Consultee Comments for Application 2025/92713

Application number: 2025/92713

Location: Rear of 23 to 43, Moor Lane, Gomersal, Cleckheaton, BD19 4LF

Proposal: Reserved matters application pursuant to outline permission 2023/92079 for erection of residential development of 10 dwellings, demolition of existing extension at 27 Moor Lane, widening of existing access and realignment of boundary walls and discharge of details reserved by conditions 4 (noise), 5 (BEMP), 6 (Arboricultural Impact Assessment), 7 (safety and security), 8 (landscape), 9 (LEDS)

PLOTS 6

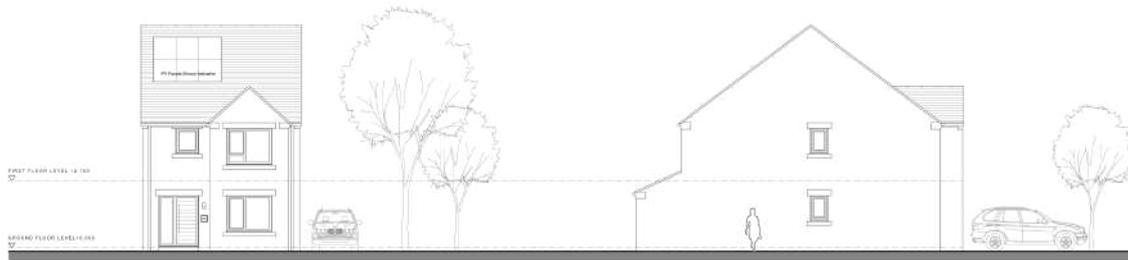
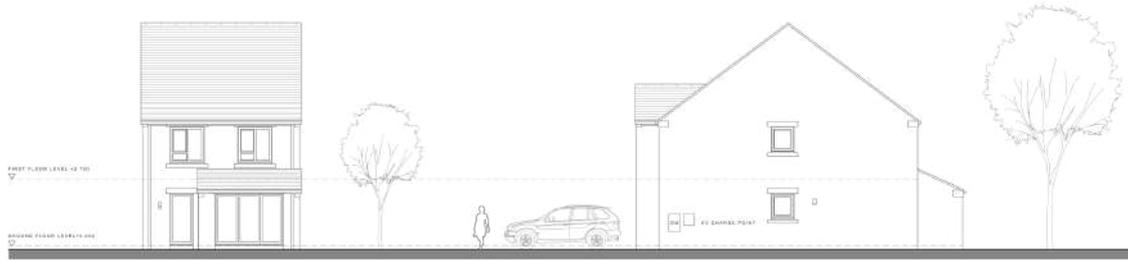
Plot 6- parking area does not appear to be overlooked.

PLOT 1

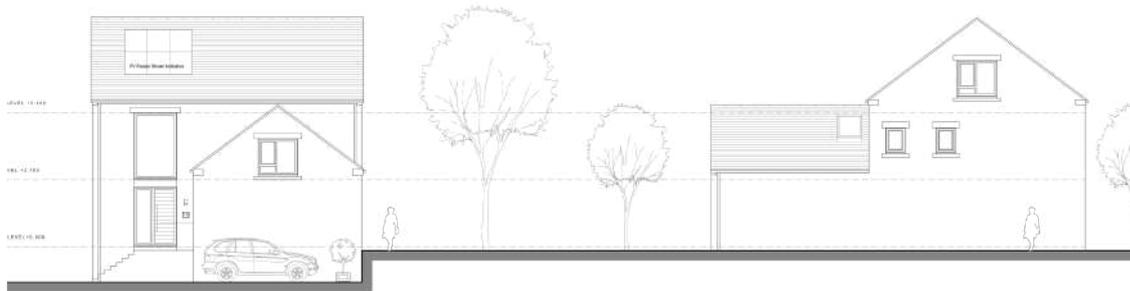
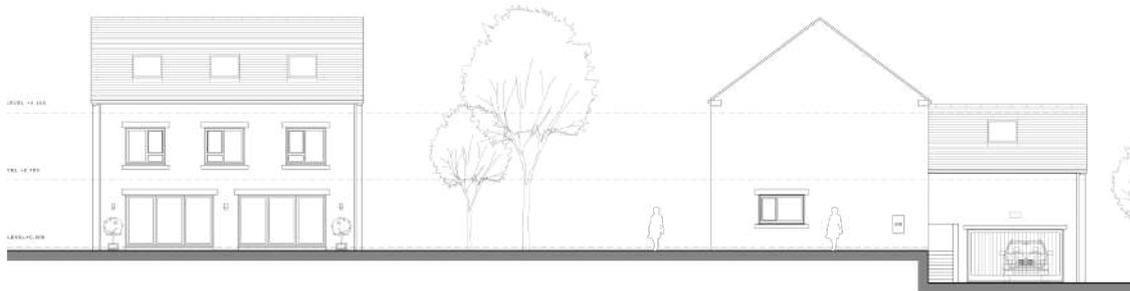
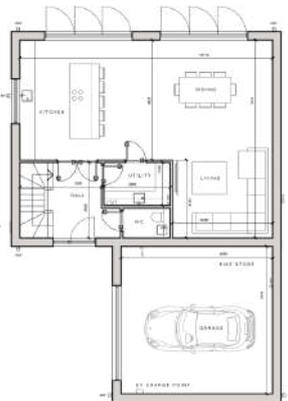
Plot 1- bins should be located behind a secure boundary line. Otherwise, they may be used to scale the fence or be repositioned and used as a climbing aid to reach the property's non-accessible windows. In addition, the parking provision does not appear to be overlooked.
